Application by Highways England for the A1 in Northumberland: Morpeth to Ellingham
The Examining Authority's written questions and requests for information (ExQ3)
Issued on 11 May 2021.

The following table sets out the Examining Authority's (ExA's) third round of written questions and requests for information – ExQ3. Questions are set out using an issues-based framework derived from the Initial Assessment of Principal Issues provided as **Annex C** to the Rule 6 letter of 19 November 2020. Questions have been added to the framework of issues set out there as they have arisen from representations and to address the assessment of the application against relevant policies.

Drawing Title **EXISTING AND PROPOSED CARRIAGEWAY AREA WITHIN ORDER LIMITS REGULATION 5(2)(c) KEY PLAN SHEET 1 OF 3**

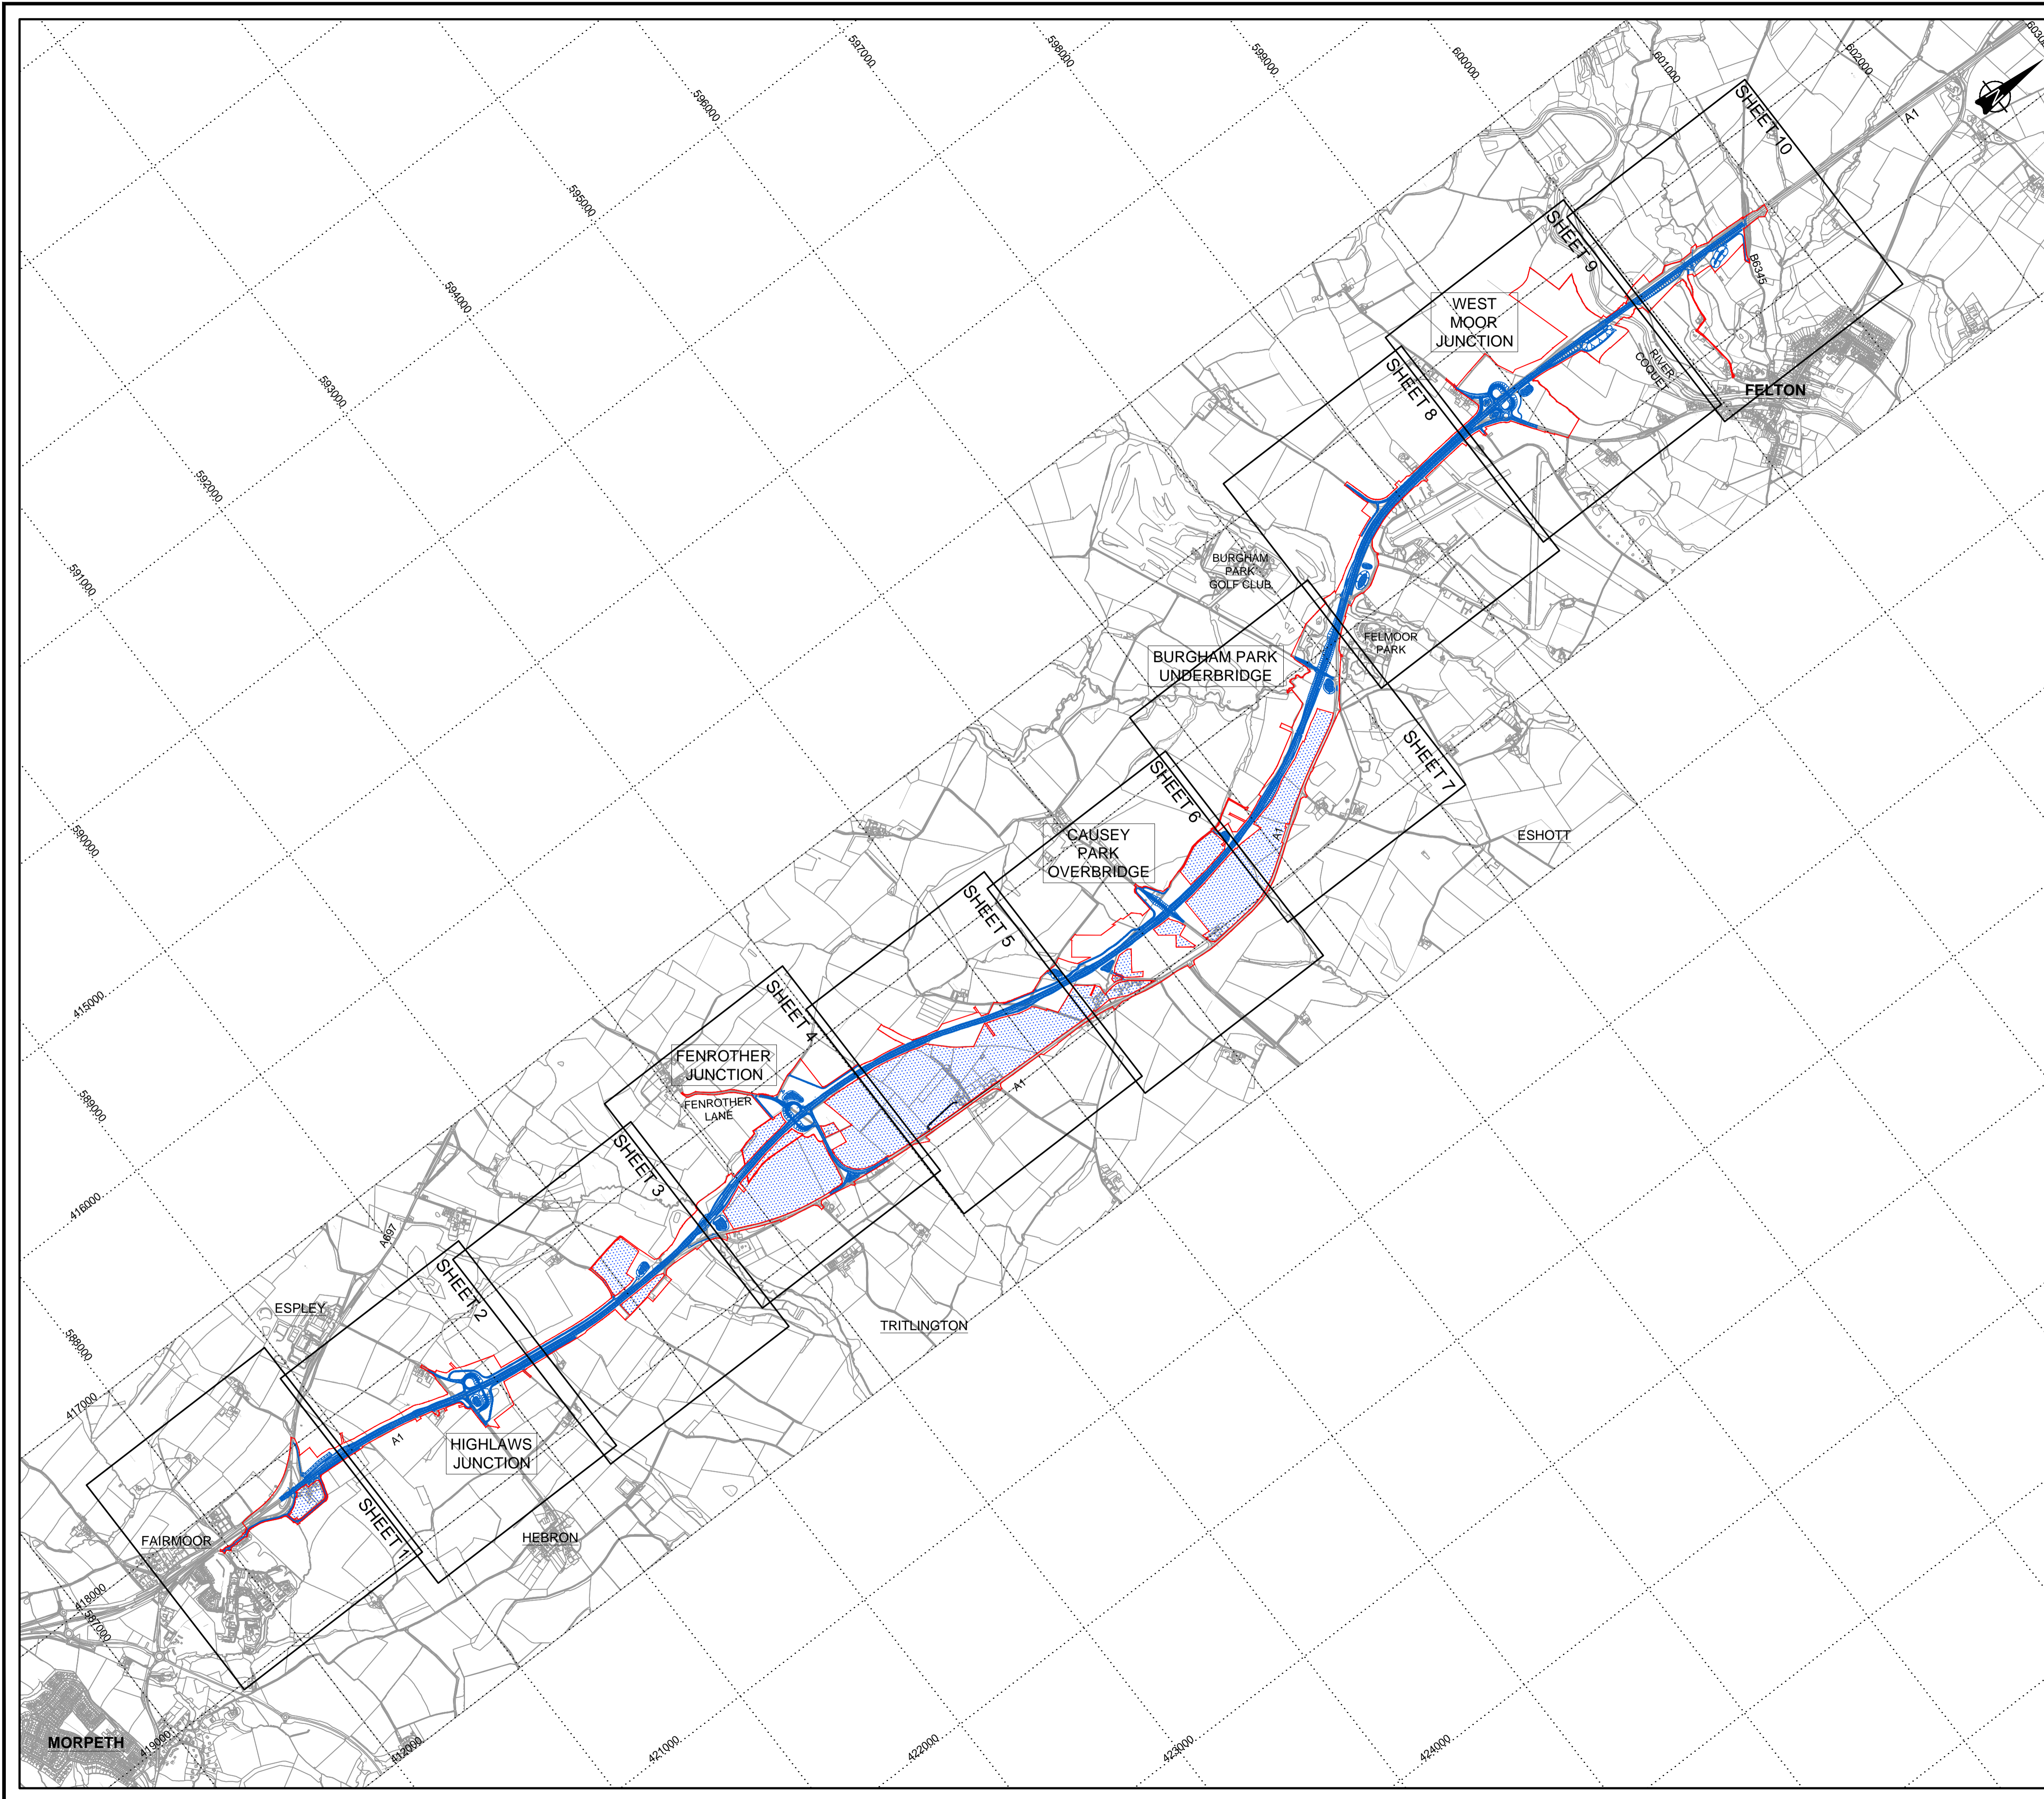
ExQ3	Question to:	Question:
		changes to the Local Plan since the submission of the application which the ExA should take into account.
GEN.3.5	Applicant	<p>At D5 the Applicant submitted Rev 3 of General Arrangement Plans for Change Request [REP5-033]. Key Plan (Sheet 1 of 3) is shown as Revision 3 although the legend does not reference Revision 2. The changes are described as "East Linkhall Access Road Widened to Two Lanes and Shipperton Burn Diversion Added for Deadline 5". Sheets 14, 15 and 16 have also been amended as Revision 1. The General Arrangement Plan was further updated at D6 [REP6-005]</p> <p>How do these amendments relate to the Change Request? Explain why Revision 2 is not referenced.</p>
GEN.3.6	NCC All IPs	<p>Changes to East Linkhall Access Road, West Linkhall Access Road and associated drainage proposed at D6 [REP6-005] are described as having been discussed with NCC.</p> <p>NCC and all other IPs are asked for their comments on the scope and effects of these proposed changes.</p>
